Rezoning Transportation Analysis

Petition Number: 2023-028

From: Jake Carpenter, PE

| Date | Description |
|---------|-------------------|
| 6-28-23 | First Review (TM) |

SHEET NUMBER  
**RZ-1**

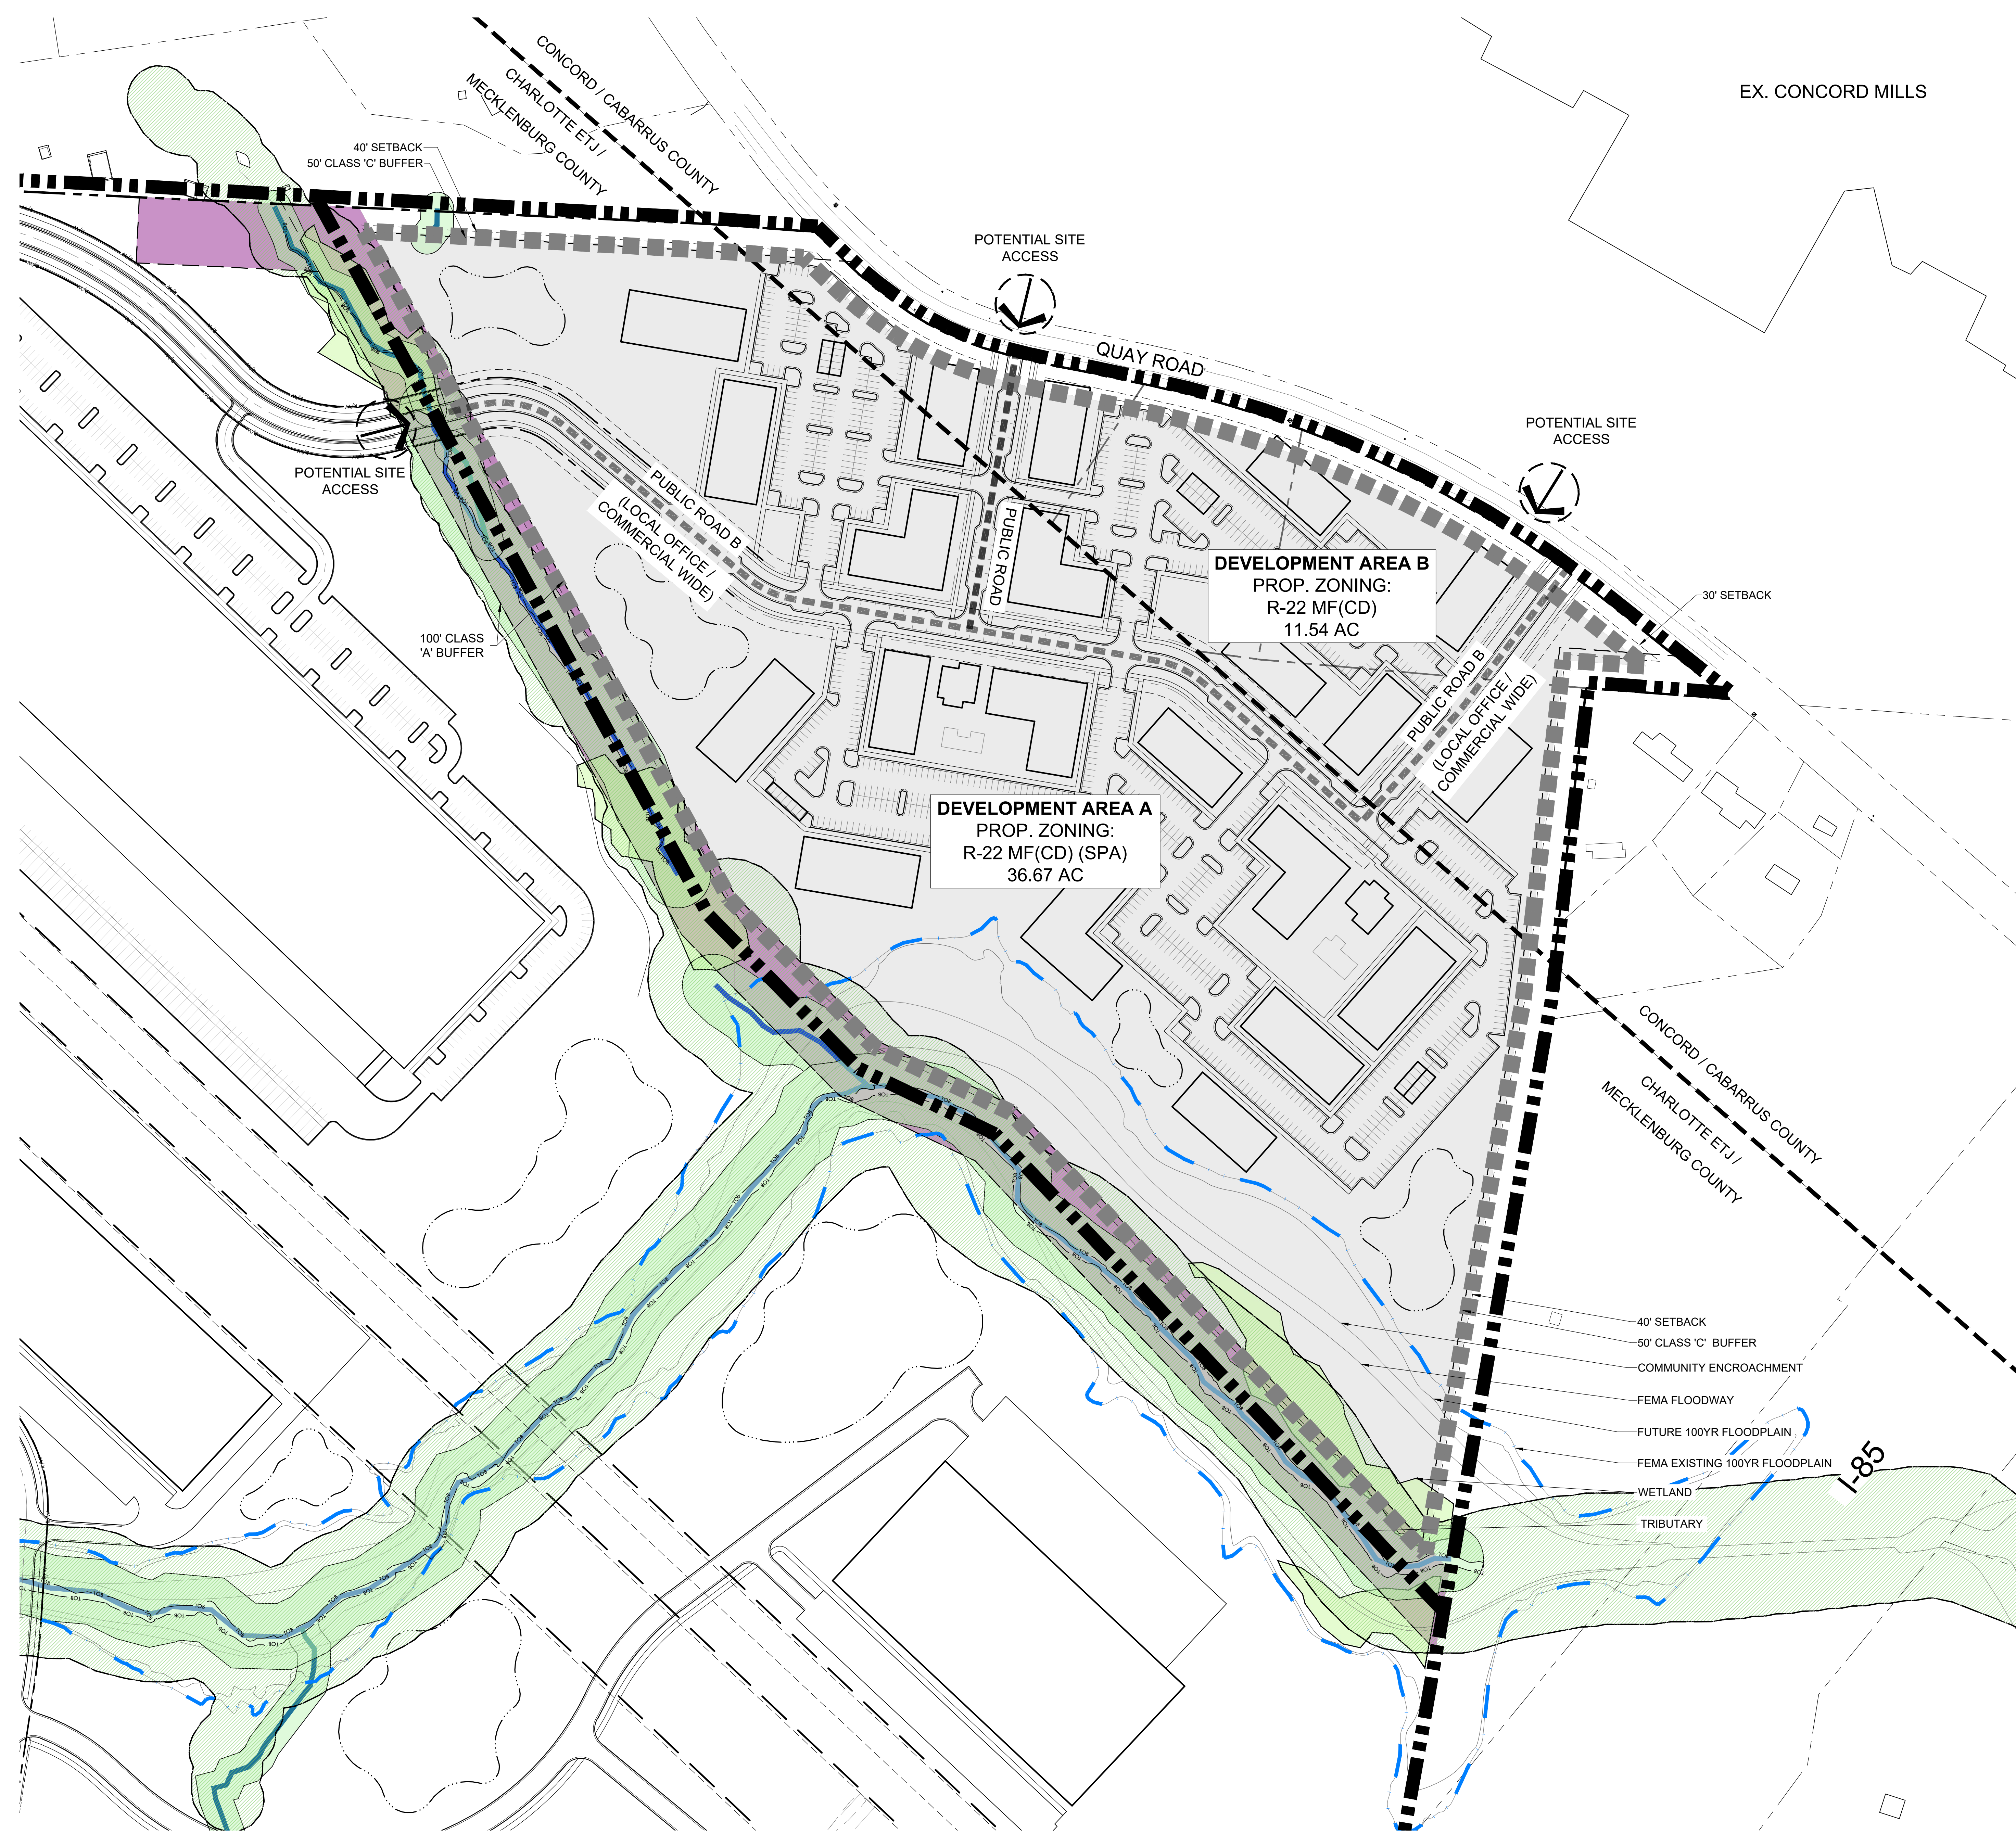
2. Revise site plan and conditional note(s) to commit to construct an 8-foot planting strip, and 8-foot sidewalk on newly N-S public Road per Chapter 20.

4. Revise site plan and conditional note(s) to commit to identifying who is maintaining each public roadway.
5. Revise site plan and conditional notes(s) to commit to coordinating with CATS to provide a public connection to the nearest CATS bus stop to the North of the site.
